I-2513 B & D 4B Meeting Minutes

I-2513B&D Concurrence Point 4B Meeting

Date: June 18, 2025
Location: CCA Structures Conference Room
Time: 1:00PM
Attendees: Hannah Headrick – NCDOT
John Jamison – NCDOT (Teams)
Todd Lapham – NCDOT
Carlos Sharpless – NCDOT (Teams)
Yates Allen – NCDOT (Teams)
Jennifer Parish – NCDOT (Teams)
Daniell Bagley – NCDOT (Teams)
Scott Jones – USACE (Teams)
Lori Beckwith – USACE (Teams)
Holland Youngman – FWS (Teams)
David Moyar – JV (Teams)
Byron Holden – RK&K
Jeremy Keene – RK&K
Pete Stafford – RK&K (Teams)
Chris Rivenbark – RK&K
Vidya Mohandas – WSP
Kase Schalois – WSP
Chris Lewis – TGS (Teams)

The Hydraulic Review was held in order to reach compliance on Merger Concurrence Point 4B, further known in the minutes as 4B, for I-2513B&D, I-26 / I-240 in Buncombe County. The following items were discussed and conclusions reached:

PERMIT DRAWING SHEET 48 OF 81

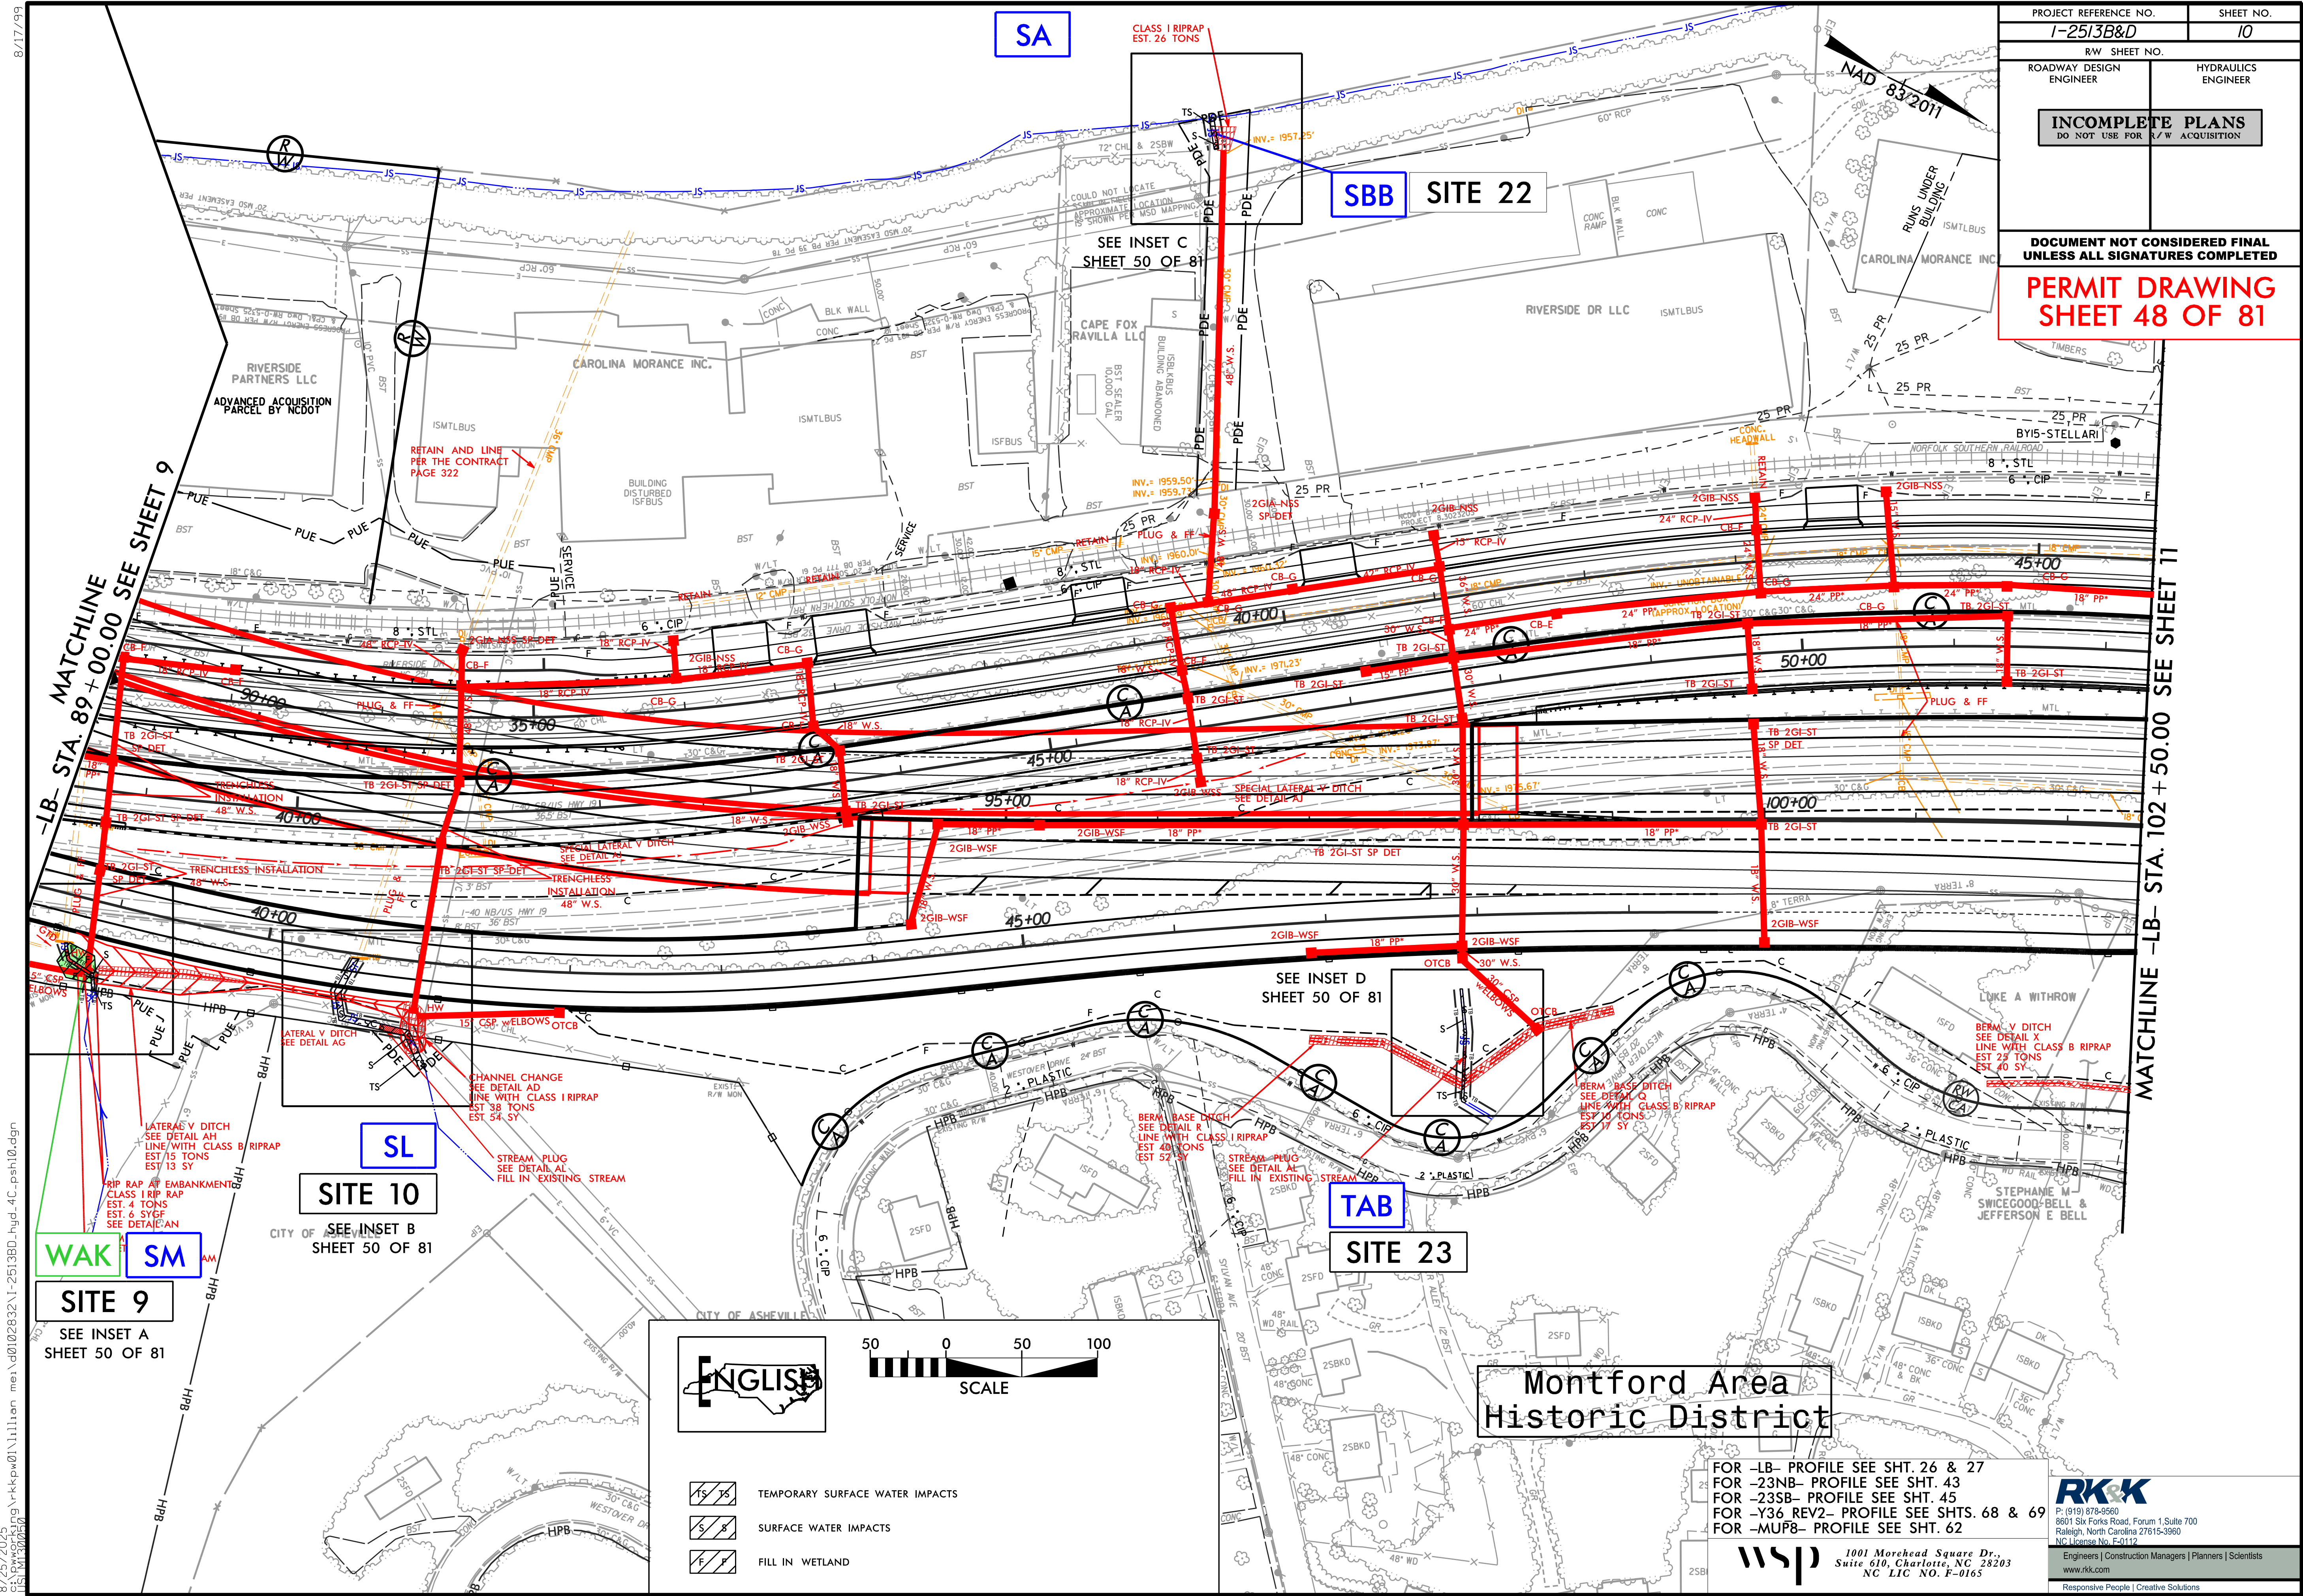
- Stream SA, French Broad River, extends onto sheet 10 but there are no impacts on this sheet.
- Stream SM is permit site 9 in the preliminary permit.
 - SM is currently carried by an existing 42" CMP. The proposed design is now carrying SM in a 48" WS pipe.

- Despite this being a jurisdictional stream, the proposed 48" WS pipe is not buried. The proposed 48" WS pipe is part of a storm drainage system that flows through seven drainage boxes and is approximately 622' long before discharging.

- It was agreed that this pipe did not need to be buried.
- Wetland WAK was identified by RK&K since the preliminary permit.
 - Since this new wetland is adjacent to stream SM, Mr. Cook asked if it could be added to Permit Site 9 and everyone agreed to this.

- Wetland WAK is a total take.
- Stream SL is permit site 10 in the preliminary permit.
 - SL is currently carried by an existing 36" CMP. The proposed design is now carrying SL in a 48" WS pipe.

- Despite this being a jurisdictional stream, the proposed 48" WS pipe is not buried. The proposed 48" WS pipe is part of a storm drainage system that flows through four drainage boxes and is approximately 541' long before discharging.

- It was agreed that this pipe did not need to be buried.
- Stream SBB was identified by RK&K since the preliminary permit.
 - This new site will be designated as Site 22 in the permit modification request.

- Stream SBB was fed by an existing 30" CMP. It will now be fed by a proposed 42" WS pipe.
 - Stream SBB is impacted by the outfall riprap protection for the proposed 42" WS pipe and will not be a total take.
